RE: Sorpresa East Annexation and Development Review; Sorpresa East Filing No. 1  
Files: CPC A 19-00068, CPC PUZ 19-00138, CPC PUP 19-00139.

The Sorpresa East Annexation and Development Review; Sorpresa East Filing No. 1  
Files: CPC A 19-00068, CPC PUZ 19-00138, and CPC PUP 19-00139 have been  
corrected to address your review comments dated February 18, 2020. We have included  
the following responses.

**CONCEPT PLAN**

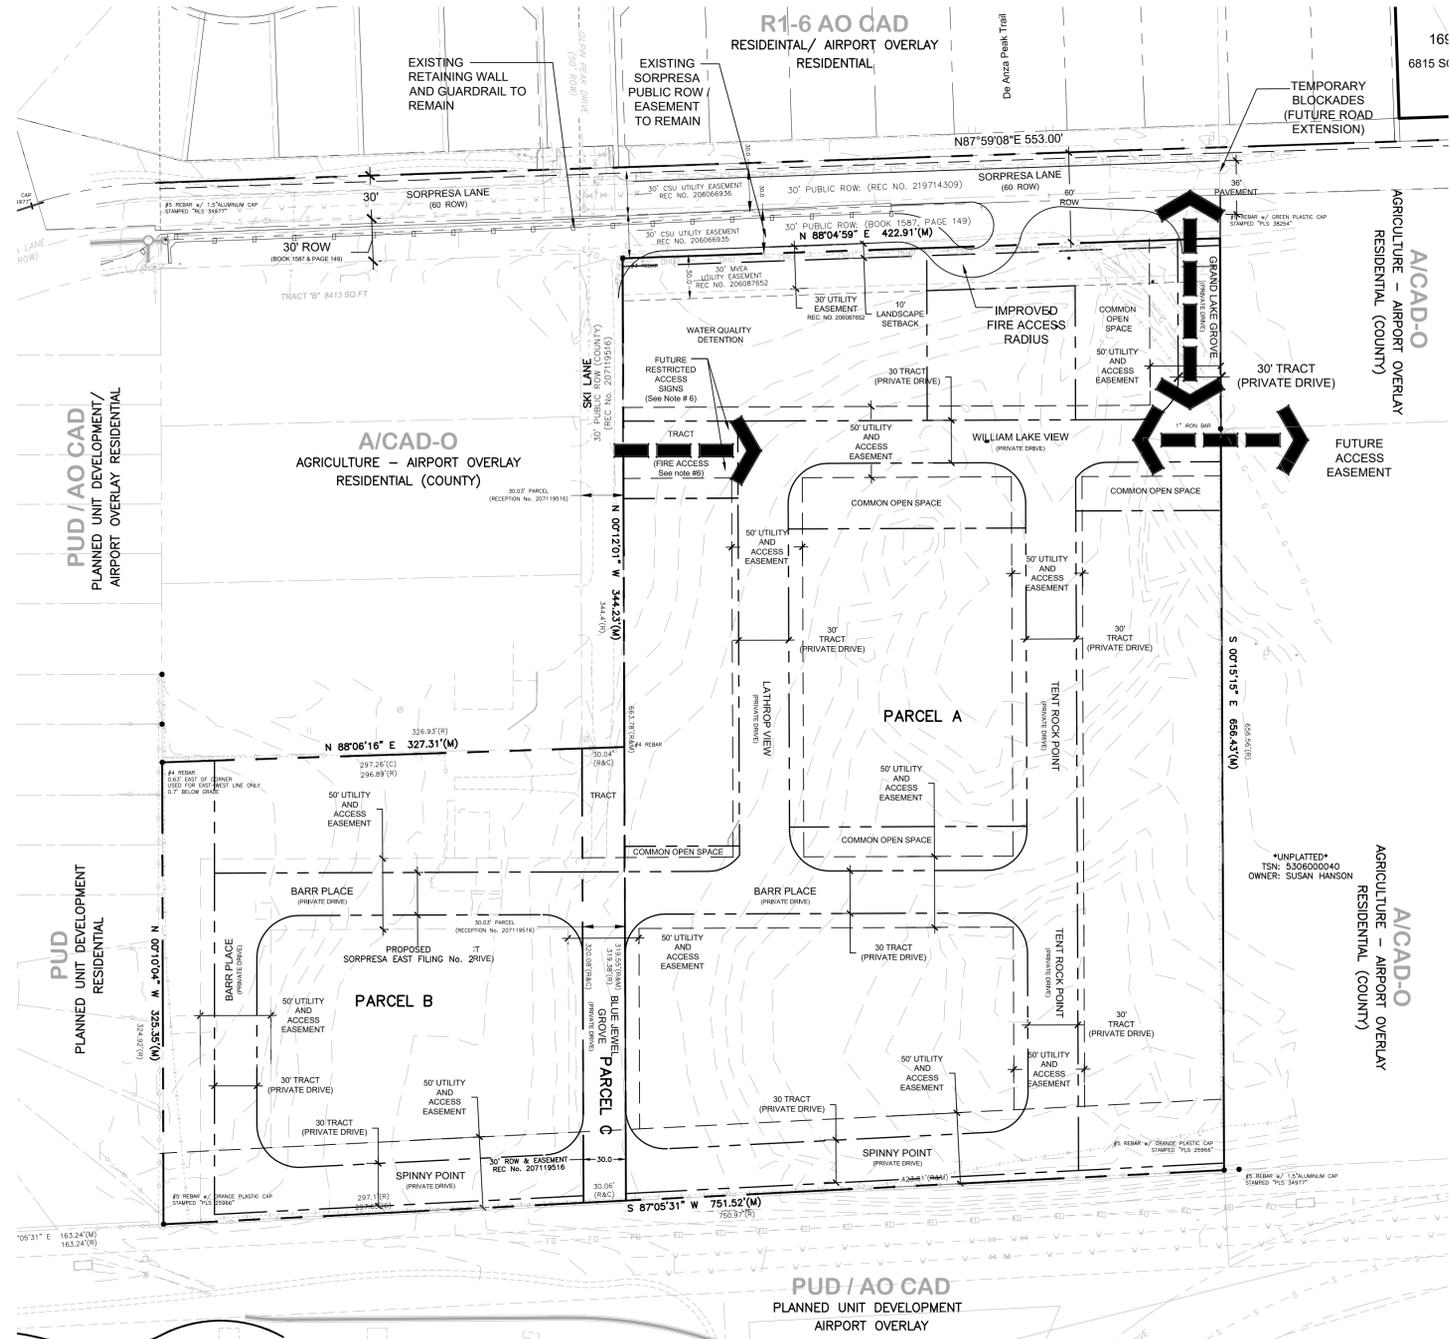
- 1. Show and label all ROW (City and County) and easements along Sorpresa Lane.  
*Response: All ROW and easements have been labeled along Sorpresa Lane.*

- 4. Label street names (Public Safety will have another review once these are added) – Label as private streets  
*Response: Privet street names have been approved by Public Safety and added to the Concept Plan.*

- 5. Staff understands streets are intended to all be private, the streets should be shown in tracts identified and noted as private roads. – Add to Note 2 that the private streets will be dedicated by plat for public use in addition to what you have stated for O&M  
*Response: Note 2 has been amended to include the requested notation that all private streets will be dedicated by plat for public use.*

- b. Please add/revise a plan note to read as follows: “NO DIRECT VEHICULAR ACCESS SHALL BE ALLOWED ONTO SKI LANE FROM THE PARCEL(S) WITHIN THIS DEVELOPMENT.” – Staff recognizes the resolution proposed with the addition of Note 5, however; please clarify how the restriction of access noted is intended to be executed. Will there be a gate/ lockbox; has this been discussed with CSFD? Or is the intent for this to be managed with signs at this location and enforced by the HOA? Please update note to what will be installed at this location. i. In addition please modify the access arrow at this location and made a call out on the site plan referencing note 5.

1. To the north of the project area are shown open circles and darkened circles which appear to be monuments that can be removed. Not addressed: To the north of the project area are shown open circles and darkened circles which appear to be monuments that can be removed.

2. In regards to the note for "access easements and agreements": do the easements need to be depicted and noted on the development plan and final plat? (See Planning comment above) Partially addressed: the access agreement to be established for the western property owners as well as the eastern property owner (General Note 1) should include the recordation number to the private access easements to be established.

1. Per recent discussions, show Sorpresa Lane with a 36' wide pavement section east of De Anza Trail.

2. Call out specific design and public improvement details along Sorpresa on the forthcoming development plan. EDR will ask for curb and gutter and 5' attached or detached sidewalks on each side of the section of Sorpresa that is to be built. In addition, the mailbox just to the west of the hairpin turn on the south of Sorpresa will have to be moved back a few feet so it is not hanging in the street.

Response: A secondary fire access, triggered by the built out of more than 50 lots, will occur at the intersection of Ski Lane and the extension of William Lake View. The tract will serve as a secondary emergency access for fire truck access only and be controlled by 'DO NOT ENTER - EMERGENCY ACCESS ONLY' signs located at the intersection of Lathrop View and William Lake View thus restricting the use by the Sorpresa East NO. 1 residents. William Lake View will be dedicated by plat for public use and therefore the 3 county parcels to the west will have full use of the private drive. See General Note #6 - Concept Plan and plan notes.

*Response: Circles removed from the plans*

*General Note # 1 refers to an access agreement between the developer and the property to the east. The note has been amended to include a recordation number which will be added after the document is recorded. The easement will be depicted on the Development Plan and Final Plat.*

A secondary fire access, triggered by the built out of more than 50 lots, will occur at the intersection of Ski Lane and the extension of William Lake View. The tract will serve as a secondary emergency access for fire truck access only and be controlled by 'DO NOT ENTER - EMERGENCY ACCESS ONLY' signs located at the intersection of Lathrop View and William Lake View thus restricting the use by the Sorpresa East NO. 1 residents. William Lake View will be dedicated by plat for public use and therefore the 3 county parcels to the west will have full use of the private drive. See General Note #6 - Concept Plan

*Response: Sorpresa Lane, between Da Anza Trail and the eastern property has been widened to 36' width. The south curb line, in order to accommodate the 'Sorpresa Ramp', tapers from ramp access to the east property line edge to a full 36' width (See plans).*

*Response: The developer will provide Sorpresa Lane improvements between Da Anza Peak Trail to the east property line including: a 36' pavement width (tapered*

from the Sopresa Ramp access point), curb and gutter and a detached sidewalk along the south side of the improvement. The developers of Cumbre Vista side of the street (north side) should be responsible for their side of the public ROW. These improvements will be illustrated on the forthcoming development plan.
